## **Development Facilitation Team (DFT) – Review Comments**

**DRB Project No: PR-2022-007348 Date: 04/26/2023 Agenda Item: #1 Zone Atlas Page: H-14**

### **Application For: SD-2023-00070-VACATION OF RIGHT-OF-WAY (DHO)**

**Plat for
Lot 1-A, Block 3, Apache Trail
Being Comprised of
Lots 1, 2 and 3, Block 3, Apache Trail; and
A Portion of Vacated 6th Street N.W. Right-of-Way
City of Albuquerque, Bernalillo County, New Mexico
March 2023**

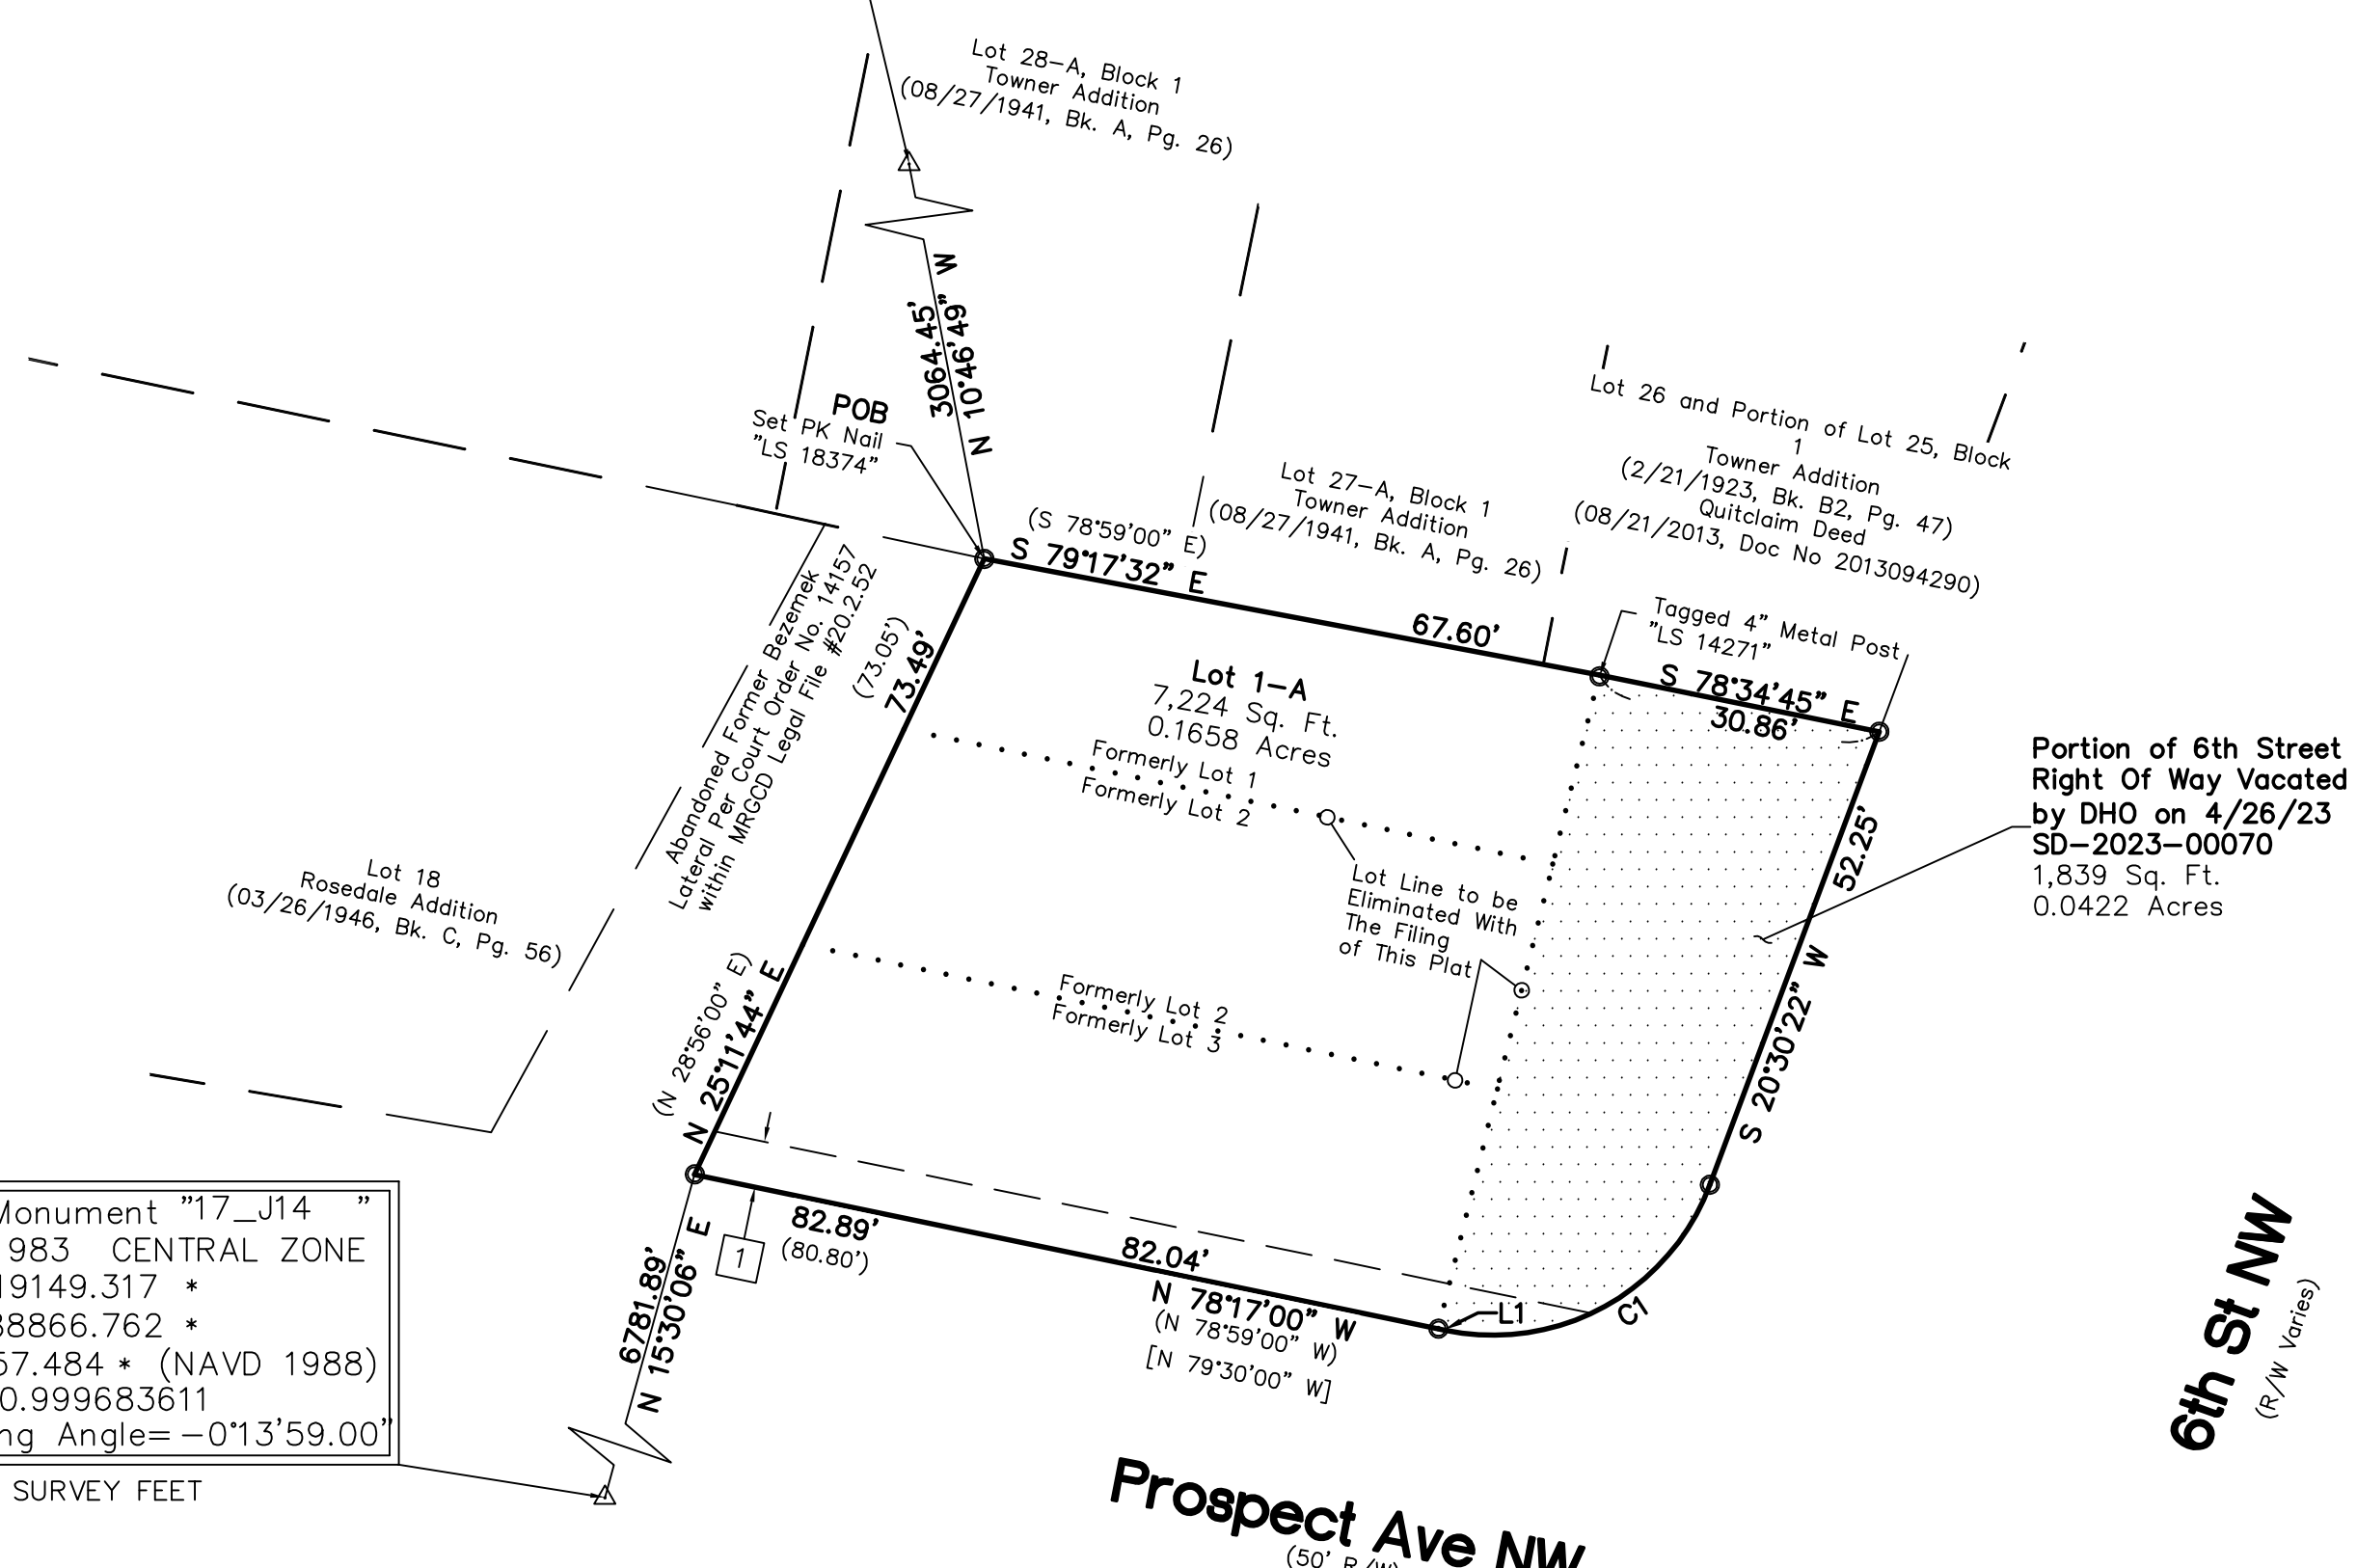
1. No objection to the proposed lot consolidation once right-of-way is vacated.
2. Please confirm the public water and public sanitary sewer infrastructure was surveyed and there is no public infrastructure within the proposed vacation area.

2. Any existing and/or new PNM easements and facilities need to be reflected on the resulting Plat.
3. There may be existing PNM facilities located within Prospect Ave and/or the portion of 6<sup>th</sup> Street proposed to be vacated. Any existing PNM facilities are located per the terms and conditions of the Franchise Agreement with the City of Albuquerque for utility facilities in public rights-of-way.

4. Any existing easements may have to be revisited and new easements will need to be created for any electric facilities in the right-of-way proposed to be vacated as determined by PNM.

Cross Sections for
Lot 1-A, Block 3, Apache Trail
Being Comprised of
Lots 1, 2 and 3, Block 3
Apache Trail and A Portion of Vacated
6th Street N.W. Right-of-Way
City of Albuquerque, Bernalillo County, New Mexico
April 2023

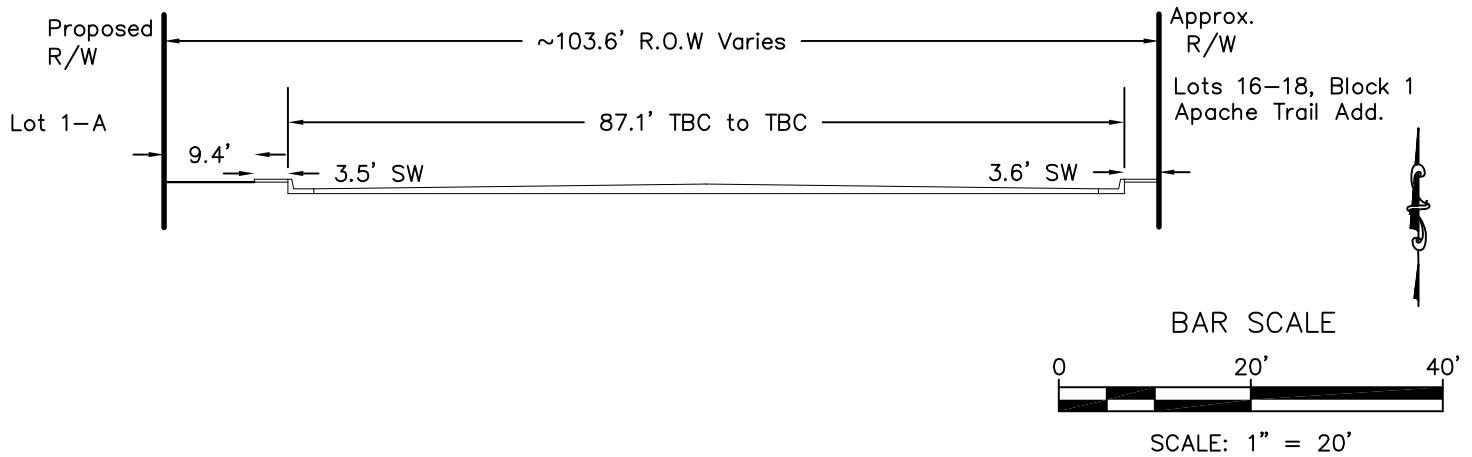
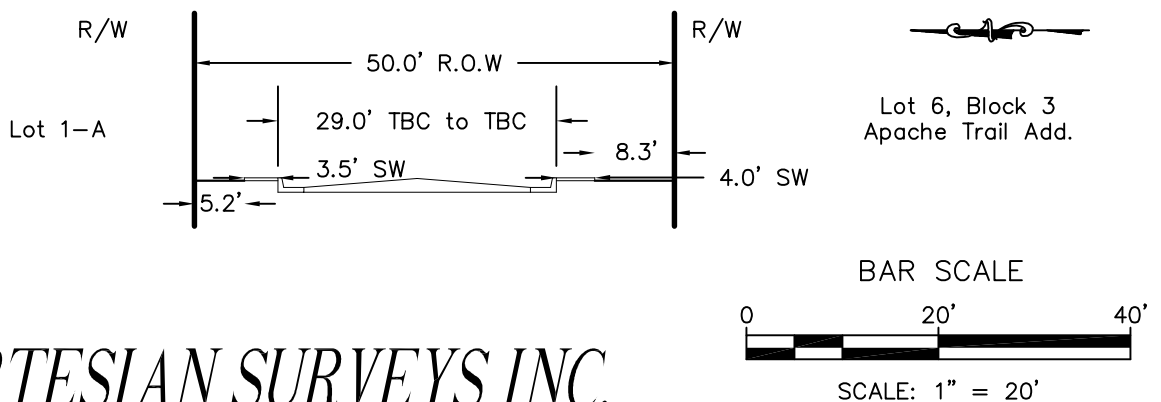
1. 6<sup>th</sup> St. is a Principal Arterial and requires 6' sidewalk with a 5-6' landscape buffer. Prospect Ave. is a Local street and requires 5' sidewalk with a 4-6' landscape buffer. From the cross sections provided it appears that ROW dedication will not be needed to achieve this. Please add these items to an infrastructure list which must be financially guaranteed. Other than this, Transportation has no objection to the vacation.

**Cross-sections provided by the Applicant confirm that there are existing sidewalks along 6<sup>th</sup> Street and Prospect Avenue with widths of 3.5-feet and 4-feet respectively. A landscape buffer exists inside the existing sidewalk along Prospect Avenue. At the time of platting, the adequacy of existing sidewalks will be evaluated.**
